Our ref: NO/2019/111800/01-L01
Your ref: 3/2019/0484
Date: 01 July 2019

**EXTENSION TO EXISTING WORKSHOP AND CREATION OF PARKING AREA.
JAMES ALPE LIMITED, LINCOLN WAY, CLITHEROE, LANCASHIRE, BB7 1QD.**

Environment Agency position

PROPOSED SITE PLAN						
Site: Vehicle Repair Centre - Workshop Extension Lincoln Way Clitheroe						
Client: James Alpe						
Date: 06.08.19	Scale: 1:500 @ A2					
Project No: ALP/21 - Dwg 06a				Drawn: AxB		
Amendments:	B

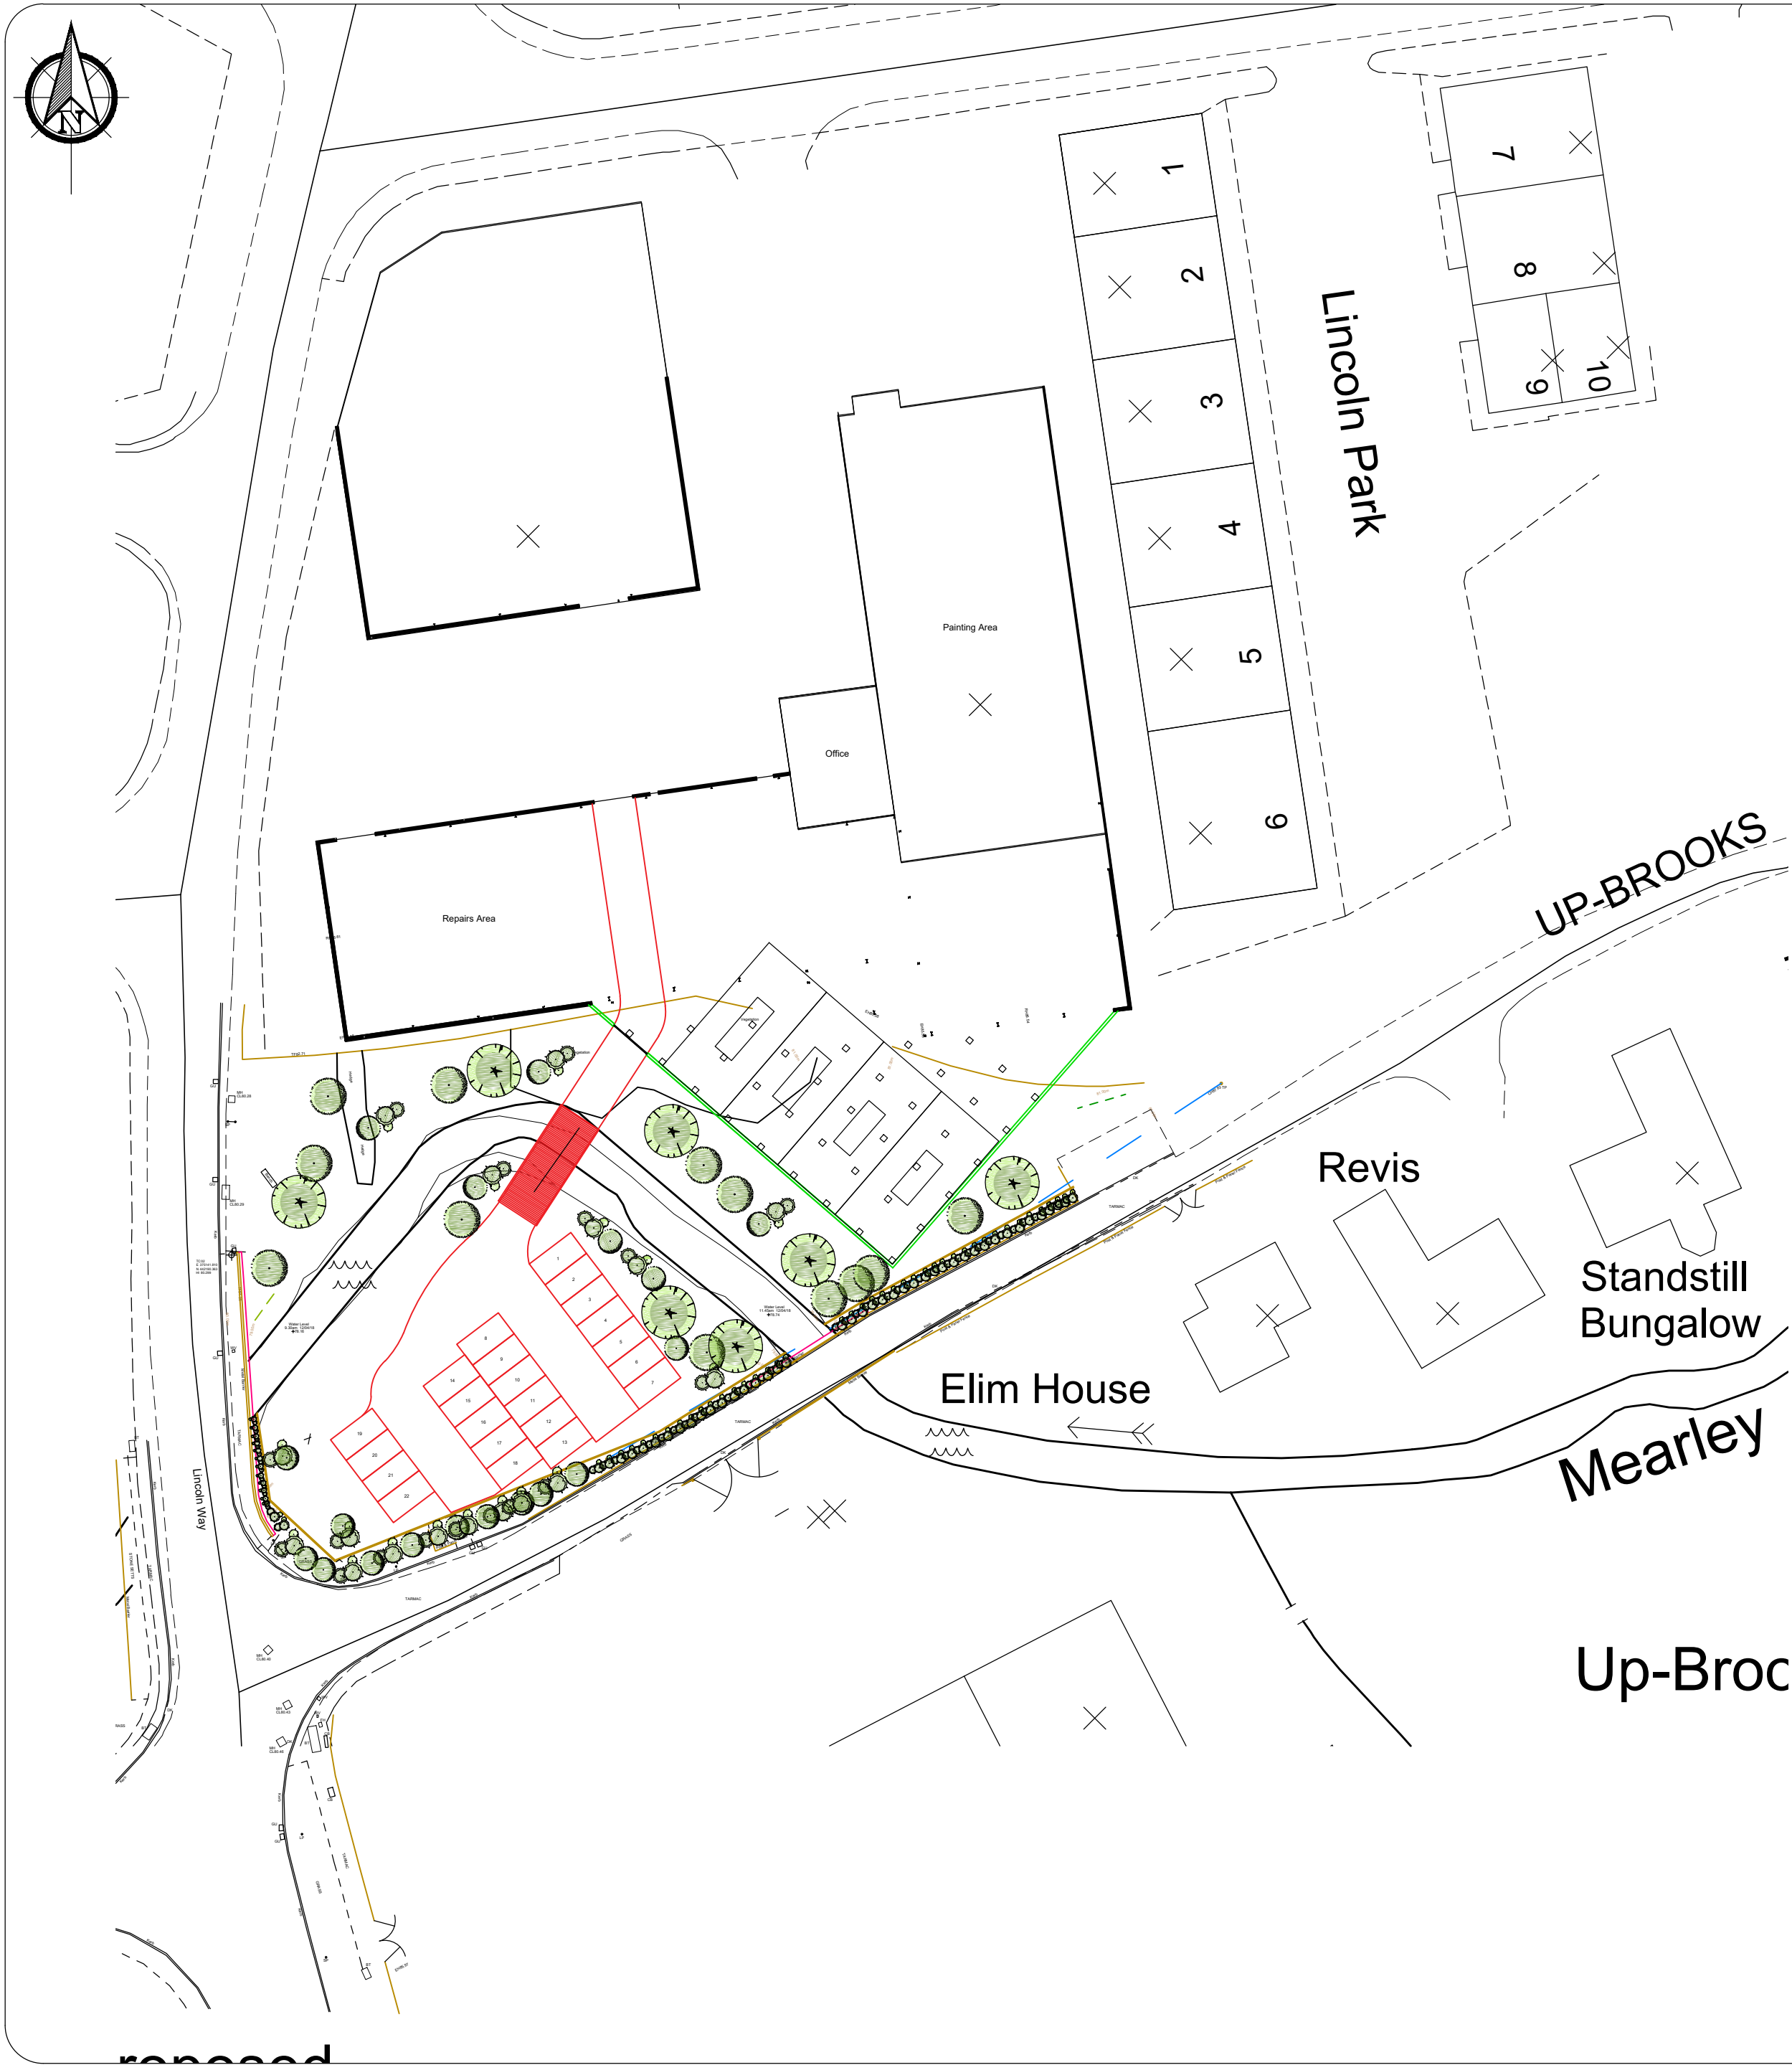
We object to this application as it involves building works within 8 metres of a Main River watercourse, Mearley Brook, in an area which is within a floodplain.

- The proposed development would infill the floodplain and obstruct flood flows, thereby increasing the risk of flooding to surrounding areas.
- The underside of the proposed bridge would need to be at least 600mm above the 1 in 100 year flood level, which would be unachievable.
- The proposed development would restrict essential maintenance and emergency access to the watercourse. The permanent retention of a continuous unobstructed area is an essential requirement for future maintenance and/or improvement works.
